Subject: Re: Requested information for application AL/18/21/HH

for Fairways, Fontwell Avenue, Eastergate PO20 3RU

Ref your letter AL/18/21/HH you letter dated the 12th February

Location Plan

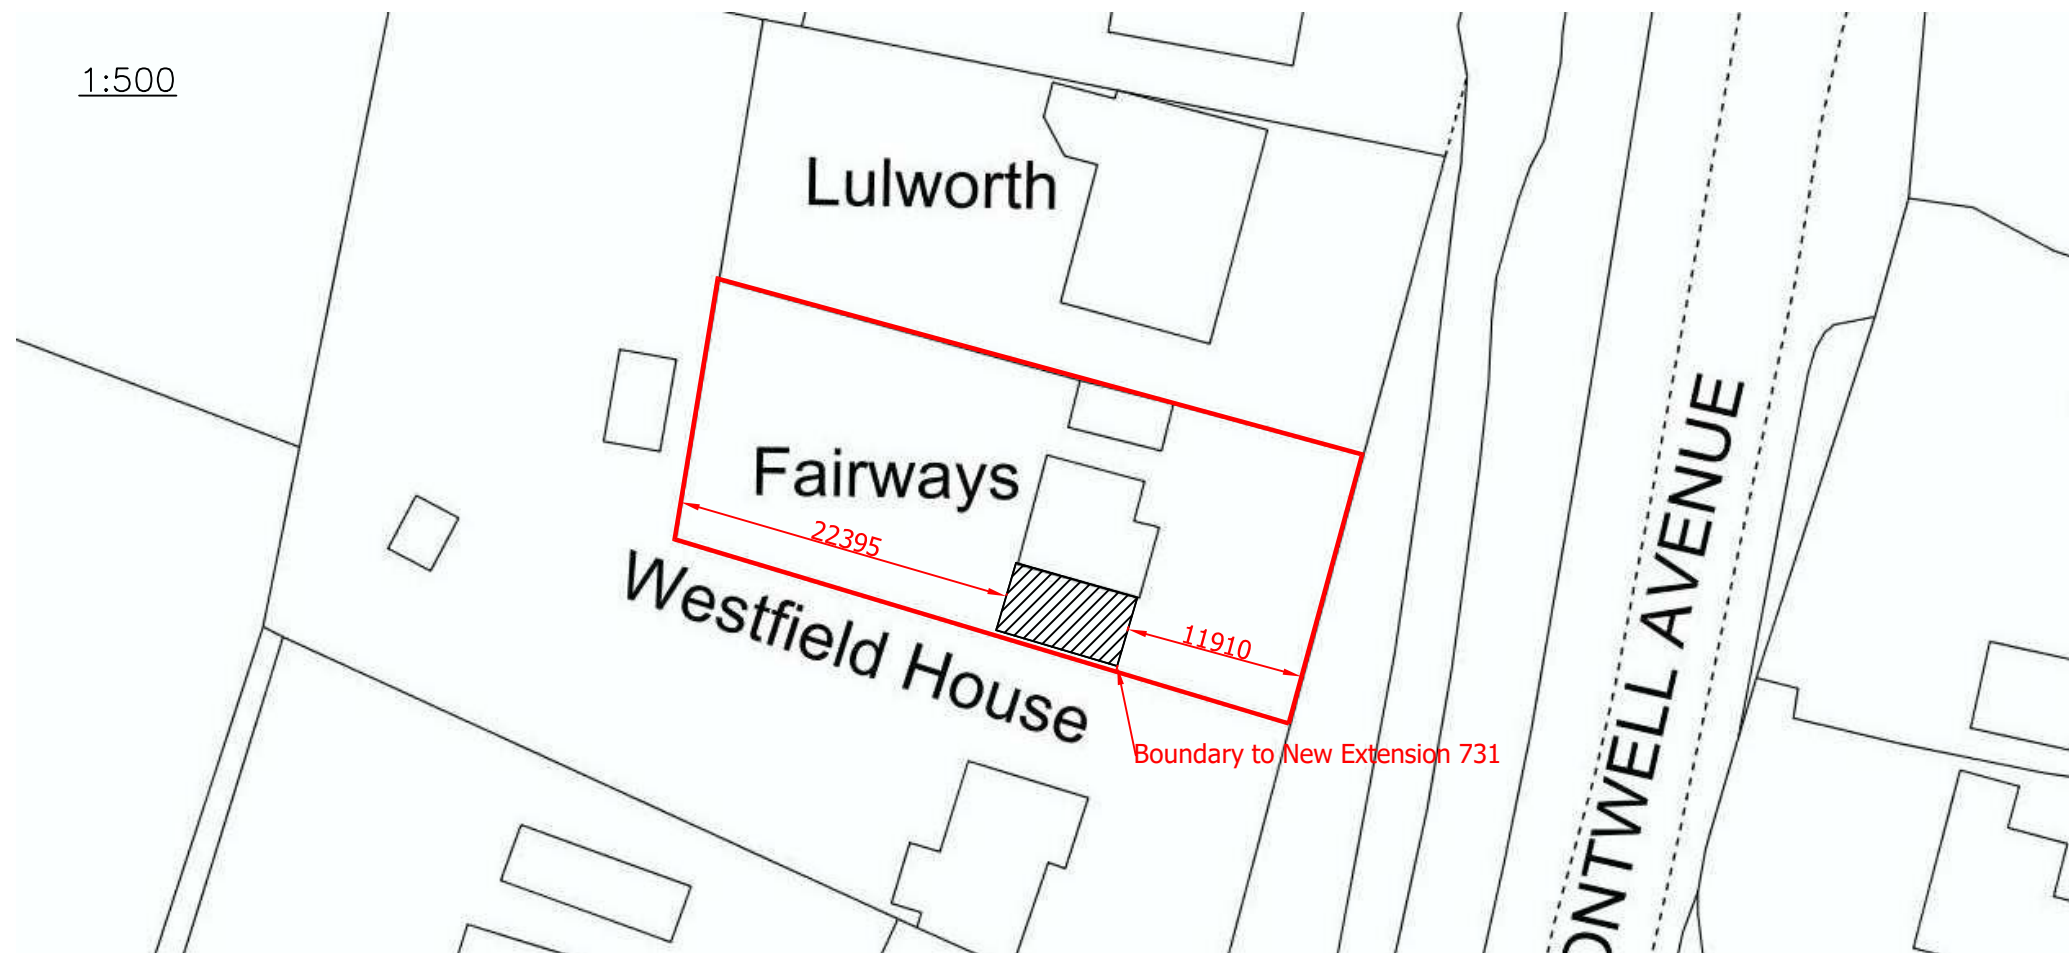
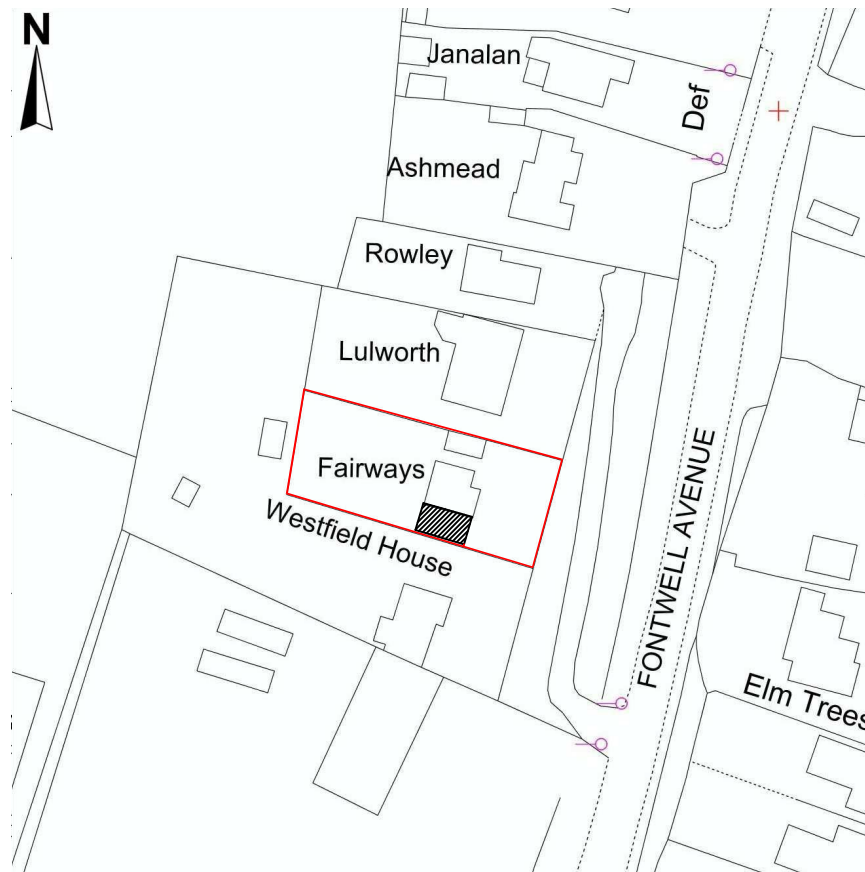
Unfortunately, this application is still invalid as the dimensions on the block plan do not measure to scale. Please review and amend accordingly.

Please find the amended Location and Block plan with the measurements on the scaled document
